# CITY OF ALBUQUERQUE

**Re: M&M Smoke Shop**  
**1800 Central SE**  
**Traffic Circulation Layout**  
Engineer's/Architect's Stamp **6-10-16** (K15-D100)

**Re: M&M Smoke Shop**  
**1800 Central SE**  
**Traffic Circulation Layout**  
Engineer's/Architect's Stamp **5-26-16** (K15-D100)

Based upon the information provided in your submittal received 5-26-16, the above referenced plan cannot be approved for Building Permit until the following comments are addressed:

SP-1

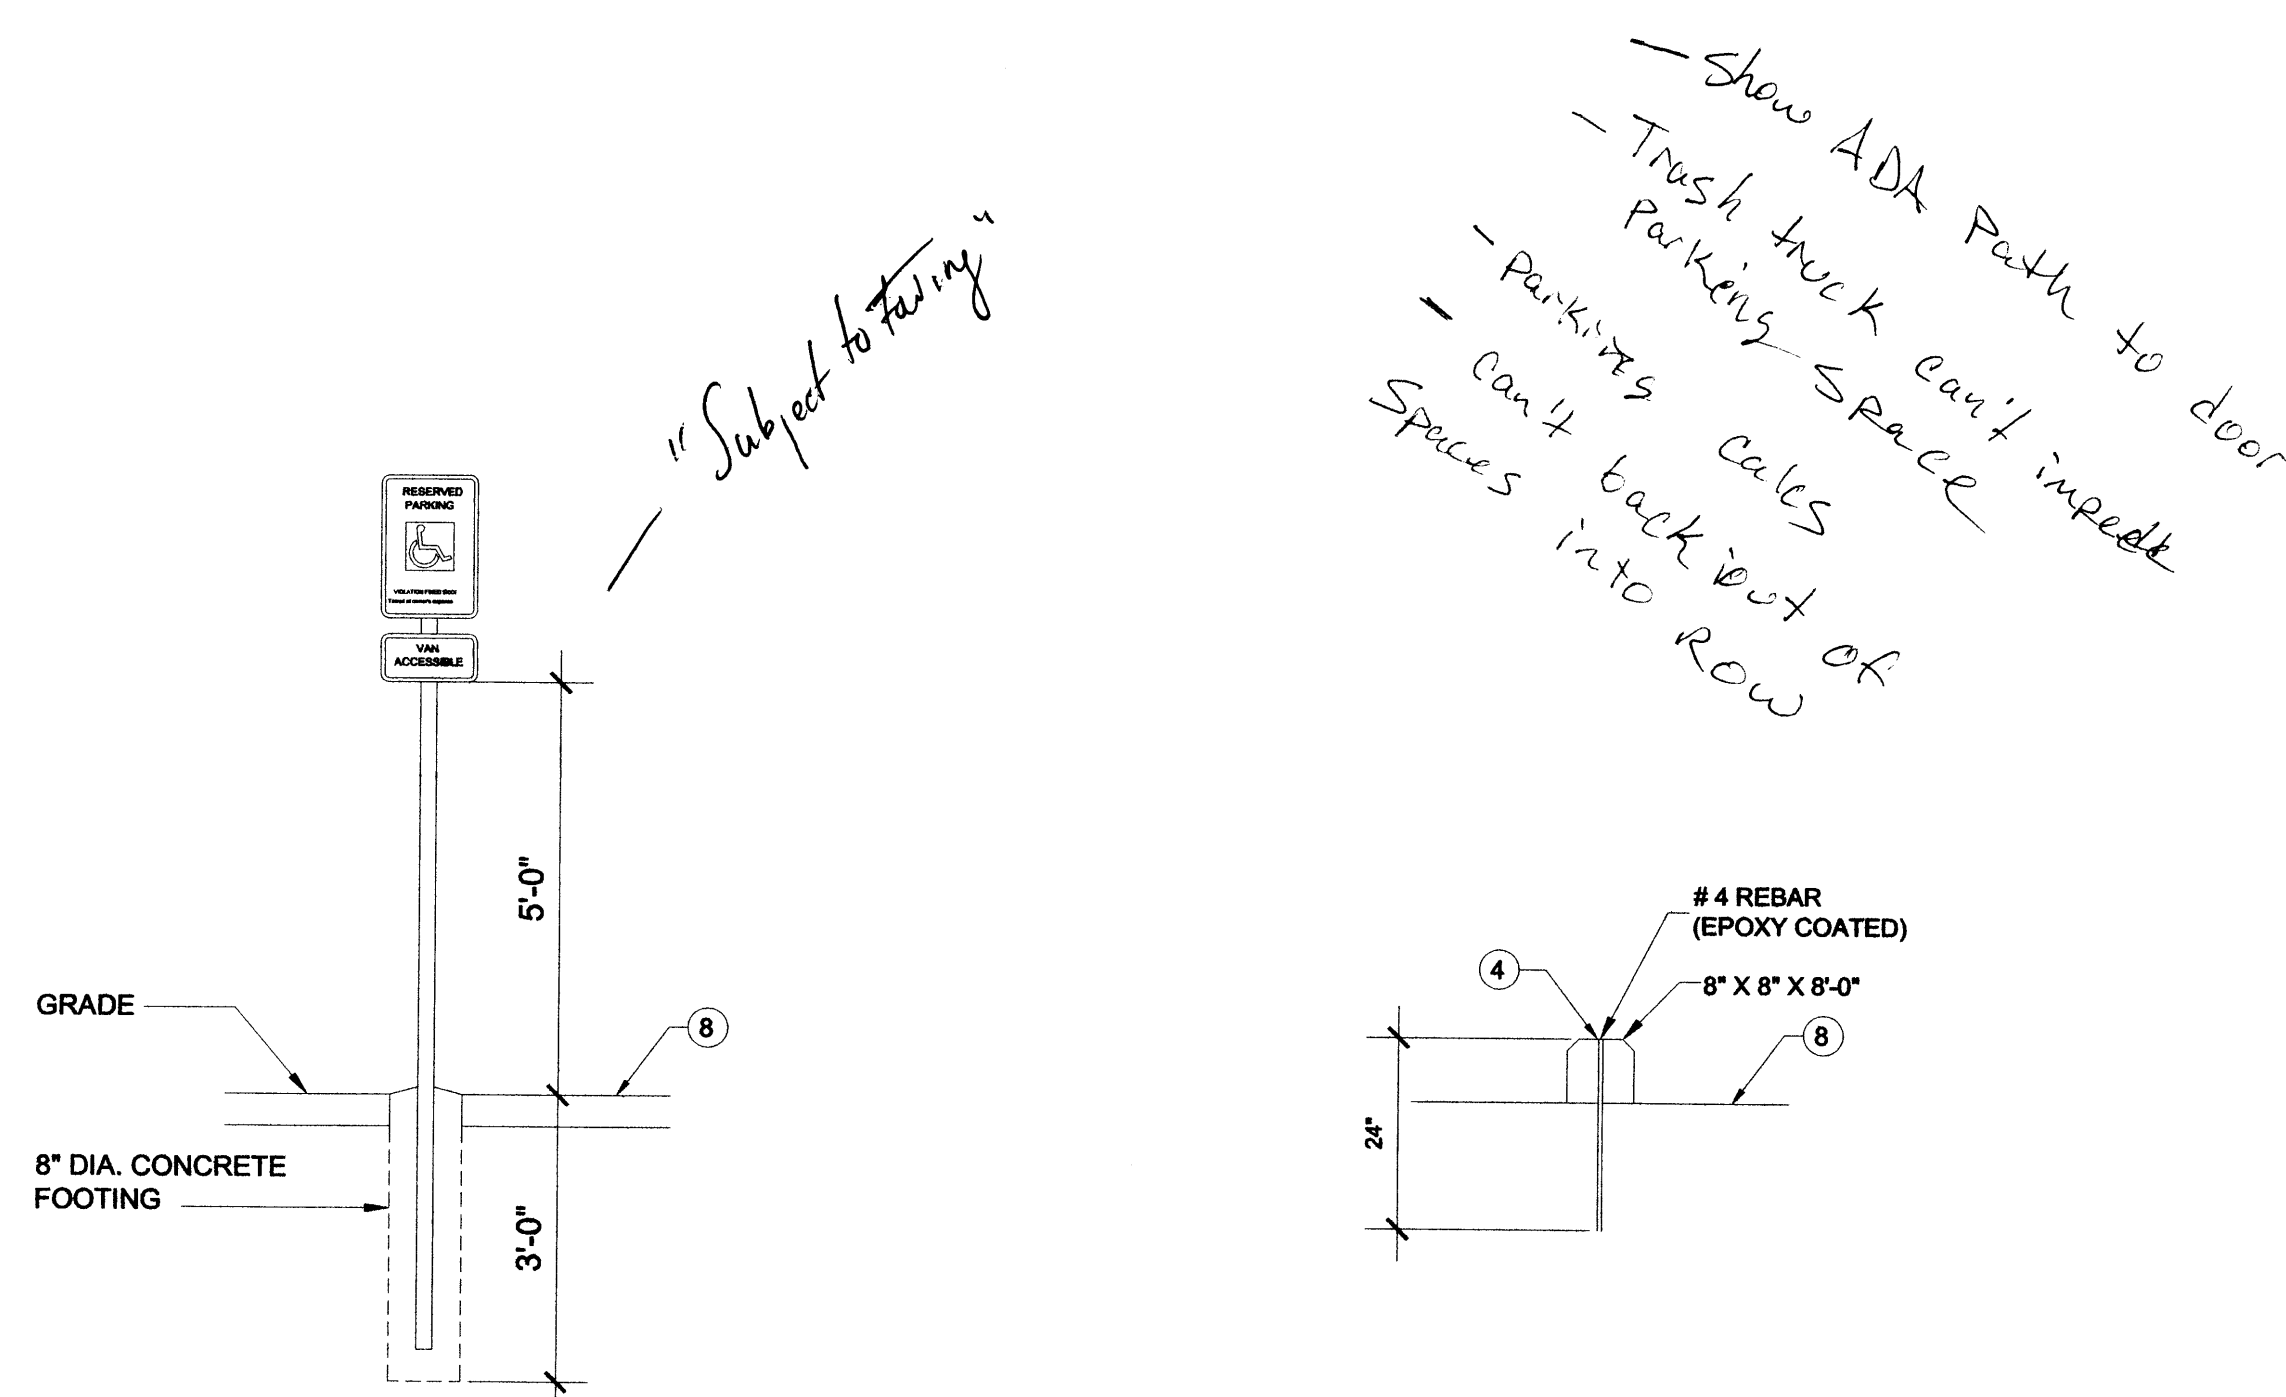
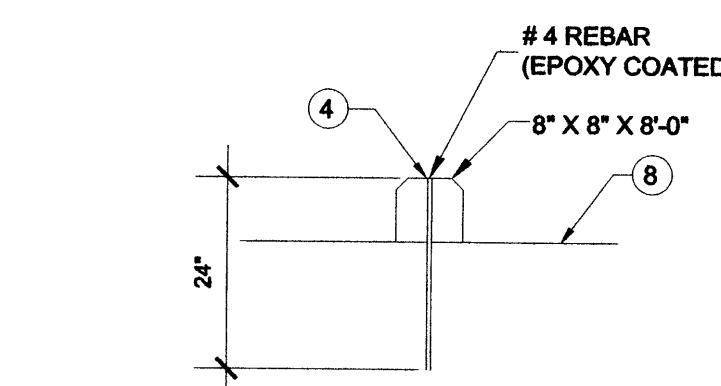
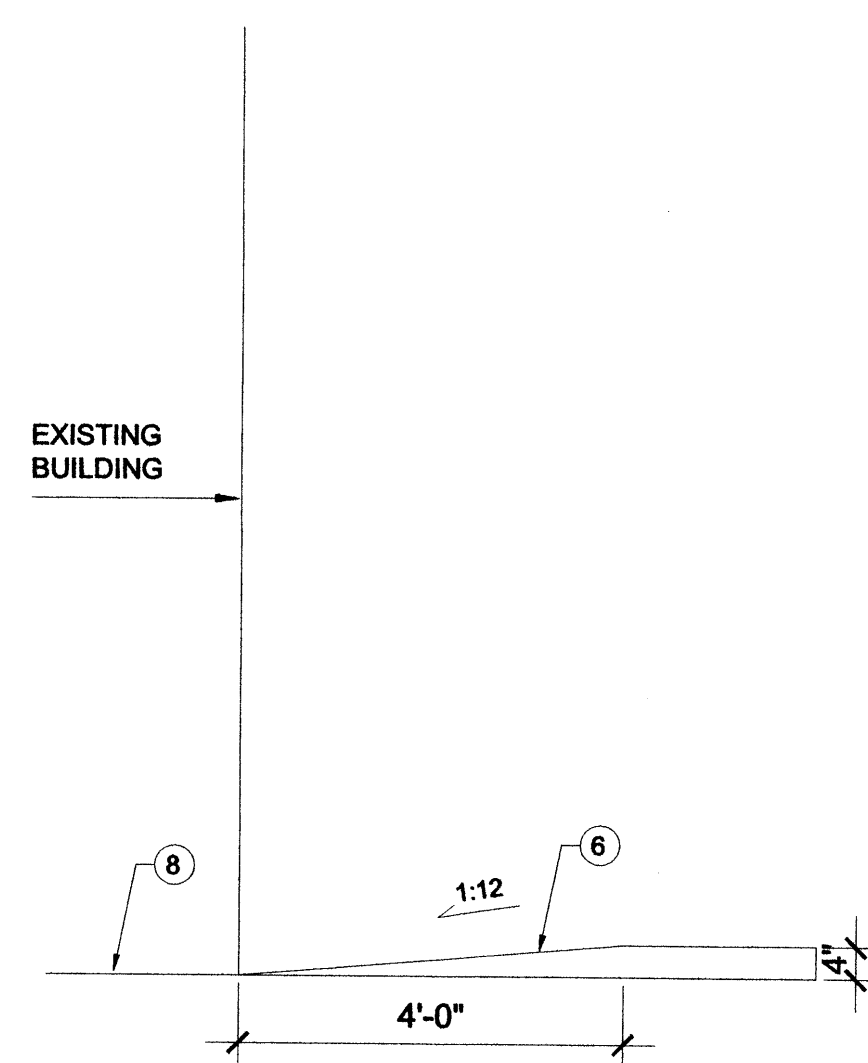
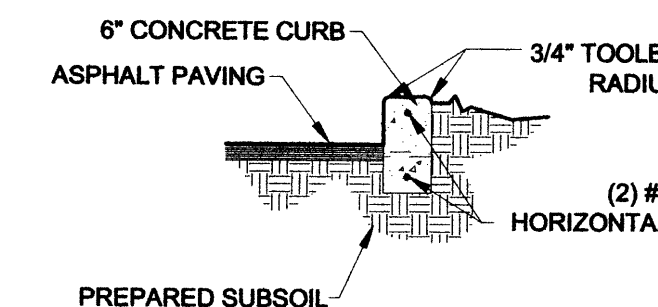
1. Please show a vicinity map showing the location of the development in relation to streets and well known landmarks.
2. List the number of parking spaces required by the zoning code as well as the proposed number of parking spaces.

3. Please identify all existing buildings, doors, structures, sidewalks, curbs, drive pads, wall and anything that influences the parking and circulation on the site.

4. Please detail and dimension all existing curb cuts and ADA ramps.
5. Identify all existing access easements and rights of way width dimensions.
6. Identify the right of way width, medians, curb cuts, and street widths on Central Ave. and University Blvd.

7. The ADA accessible parking sign must have the required language per 66-7-352.4C NMSA 1978 **"Violators Are Subject to a Fine and/or Towing."** Please call out detail and location of HC signs. Please show this detail.

8. The ADA access aisles shall have the words **"NO PARKING"** in capital letters, each of which shall be at least one foot high and at least two inches wide, placed at the rear of the parking space so as to be close to where an adjacent vehicle's rear tire would be placed. (66-1-4.1.B NMSA 1978)

9. Show all drive aisle widths and radii.
10. Per DPM, a 6 ft. wide ADA accessible pedestrian pathway is required from the public sidewalk to the building entrances. Please clearly show this pathway and provide details.

11. Per DPM, a 6 ft. wide ADA accessible pedestrian pathway is required from the HC parking stall access aisles to the building entrances. Please clearly show this pathway and provide details.

12. Provide a min 6" or max 8" high concrete barrier curb or other acceptable barrier between landscaping and parking areas and/or drive aisles. Please call out detail and location of barrier curb.

13. Design delivery vehicle route needs to be shown.
  14. Service vehicle and/or refuse vehicle maneuvering must be contained on-site; provide a copy of refuse approval. Trash trucks cannot impede parking spaces.

15. Please provide a sight distance exhibit (see the *Development Process Manual, Chapter 23, Section 3*). Please show detail from the exit/entrance off of the public alley.

16. Please add the following note to the clear sight triangle: "Landscaping and signage will not interfere with clear sight requirements. Therefore, signs, walls, trees, and shrubbery between 3 and 8 feet tall (as measured from the gutter pan) will not be acceptable in this area."

17. Unused curb cuts must be replaced with sidewalk and curb & gutter. A build note must be provided referring to the appropriate City Standard drawing. The curb cut on the south west side of building must be removed and replaced with COA standard curb and gutter.

18. It is not permissible for vehicles to back out onto University Blvd. from the parking stalls. Please provide and detail signs and pavement markings stating direction of exit.

19. All broken or cracked sidewalk must be replaced with sidewalk and curb & gutter. A build note must be provided referring to the appropriate City Standard drawing.
